GATWICK AIRPORT NORTHERN RUNWAY PROJECT

Comments on The Applicant's Response To The ExA's Written Questions (ExQ1)

Response to [\[REP3-105\]](#) | Water Environment

DEADLINE 4: 15 May 2024

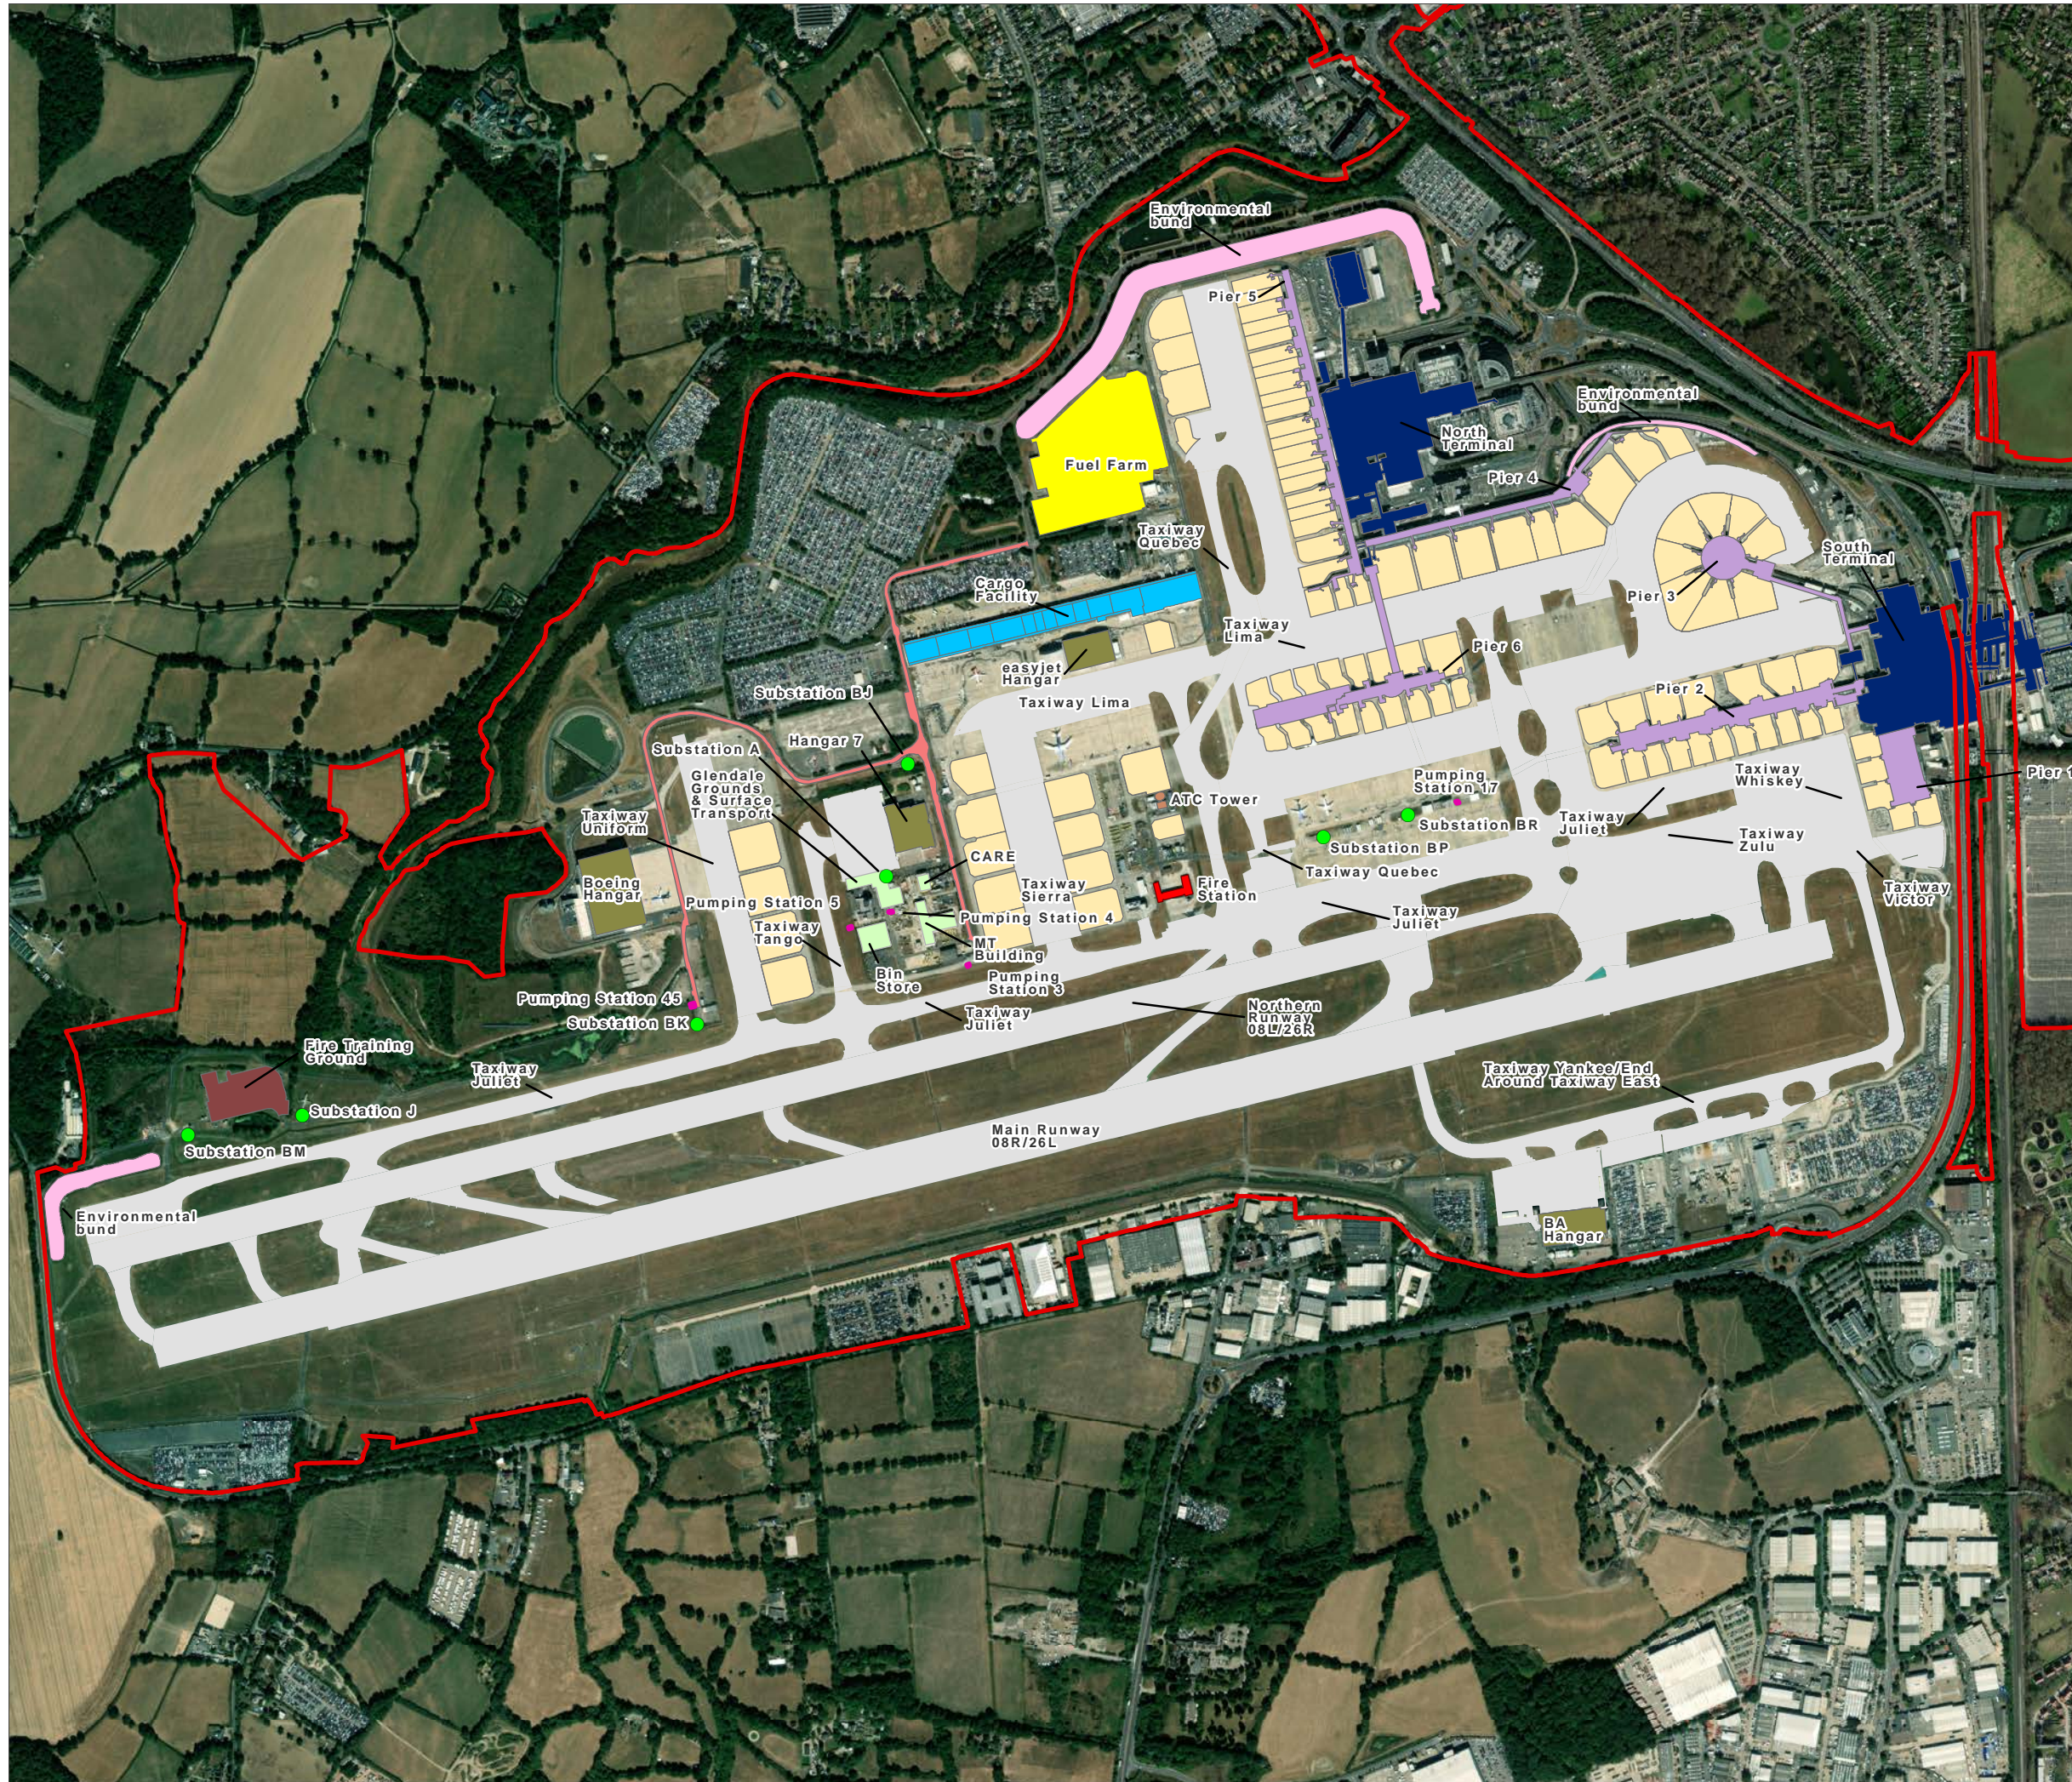
<p>evident from the aerial photography that the original terminal and station infrastructure has been extended and remodelled since this time. It would therefore be reasonable to assume that the flood risk modelling was re-calculated by the airport operator as the footprint of the buildings were extended.</p> <ul style="list-style-type: none"> • Some of the airport buildings and elements which have clearly been in situ in their current form for around 40 years include: • Pier 3 – which is circa 40 years old • Pier 2 – which appears to have been extended westwards between 1981 and 1991, but the substantial element of this is over 40 years old • Multi Storey Car Parks 1, 2 and 3 at South Terminal east of railway (see Figure 4.2.1b [REP1-019])– all under construction in 1981 – footprints unchanged and not proposed to be altered as part of DCO • Offices known as Ashdown and Atlantic House (just north of main South Terminal Building) – footprints unchanged and not proposed to be altered as part of DCO • BA Hangar (located on the southern boundary of the airfield – see Figure 4.2.1a) – constructed between 1971 and 1981 – not proposed to be changed as part of DCO.

<ul style="list-style-type: none"> Given the duration of the proposed DCO project, which covers a period of expansion to 2047 (a period in excess of 20 years), a large amount of the existing infrastructure is also proposed to be unchanged and would therefore be in situ in excess of 40 years by the end of this implementation period. Two such examples are the environmental bunds (see Figure 4.2.1a) which were clearly constructed by 1991 (the date of the next aerial photography) and the Cargo sheds – in situ by 1991. <p>As the above examples demonstrate, the design life of the airfield works is likely to be greater than 40 years. Even though some of the elements may be changed or replaced after 40 years, the structures will not be demolished and the land will not be returned back to its natural state and will therefore continue to impact flood risk and drainage beyond 40 years. Changes to the airfield works after 40 years may not need new planning permissions and may not result in an updated drainage strategy which accounts for the changes beyond 40 years. Therefore, the Applicant should consider a longer design life for the airfield works at this stage of the design.</p>
